# Transport

## ENVIRONMENTAL ASSESSMENT (MP08\_0244) 23-37 LINDFIELD AVENUE AND 11 HAVILAH AVENUE, LINDFIELD

RL 94.00  
**LOWER GROUND  
 FLOOR PLAN**  
 SK 0 2

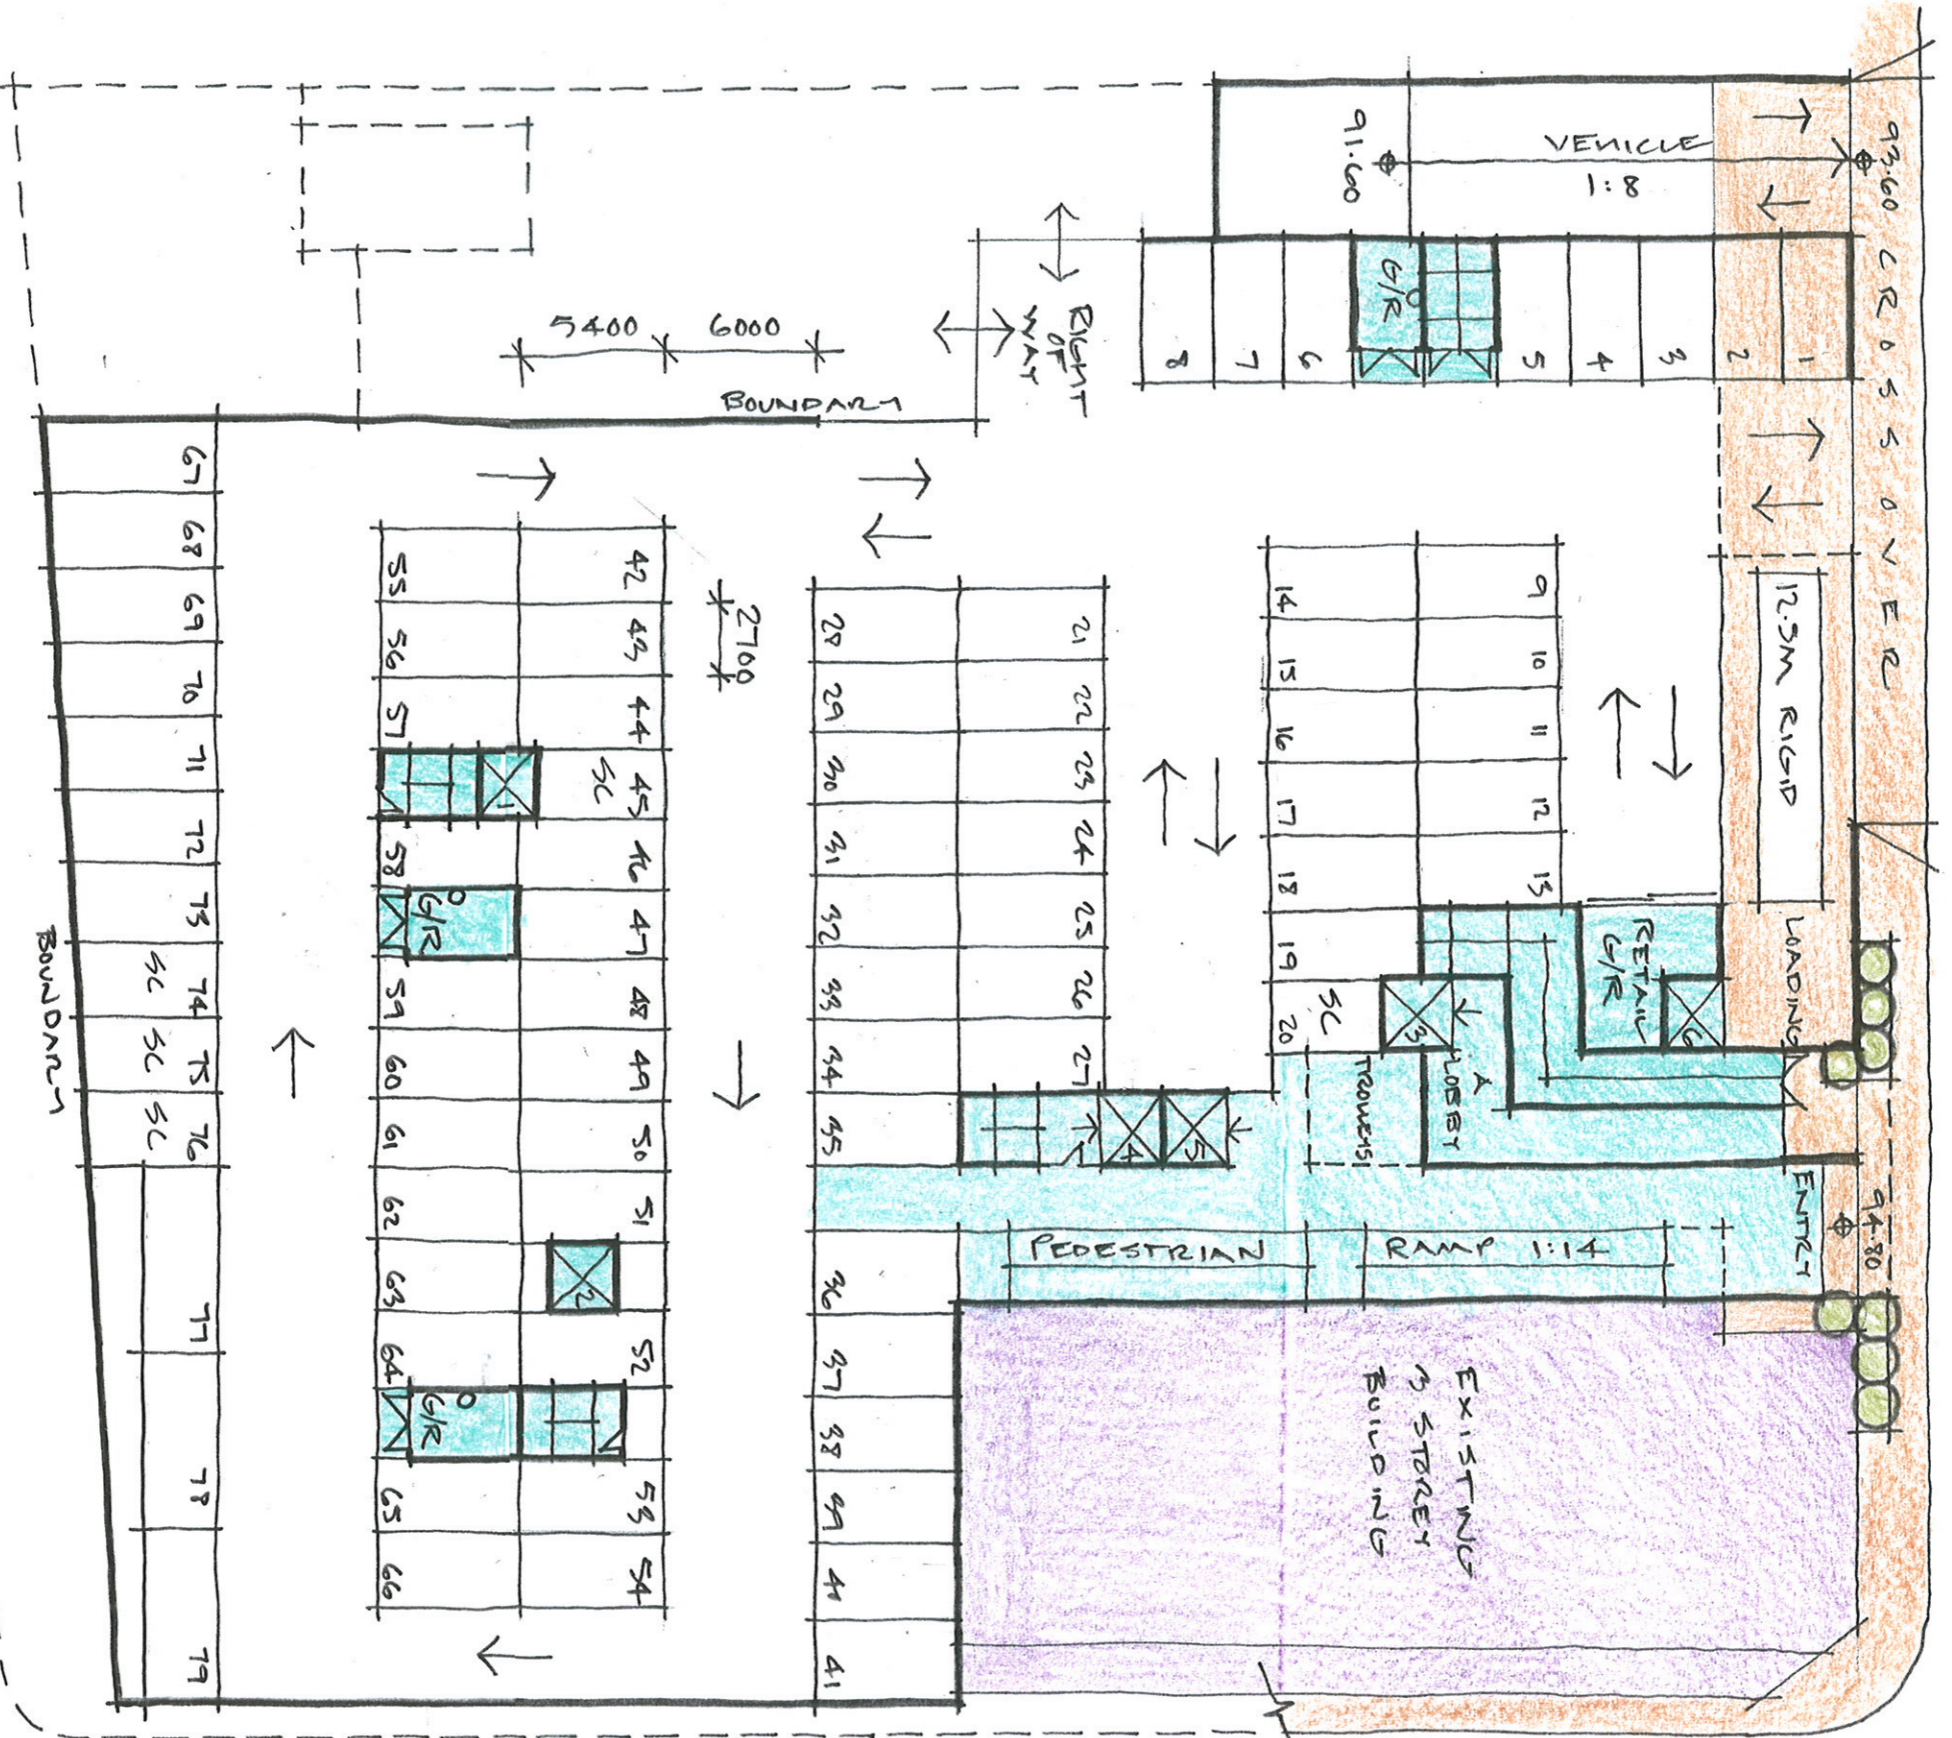
In particular, TNSW notes the proponent's parking survey has demonstrated ample existing parking supply, and requests a reduction in proposed parking provision to support State policy objectives and complement the site's high public transport accessibility.

Bicycle parking should be consolidated into more convenient, prioritised and legible locations close to the car park entries and lifts, and bicycle parking should be provided at street pedestrian entries for retail customers' convenience.

Furthermore, car share spaces must all be independently accessible and not queued as in the current designs.
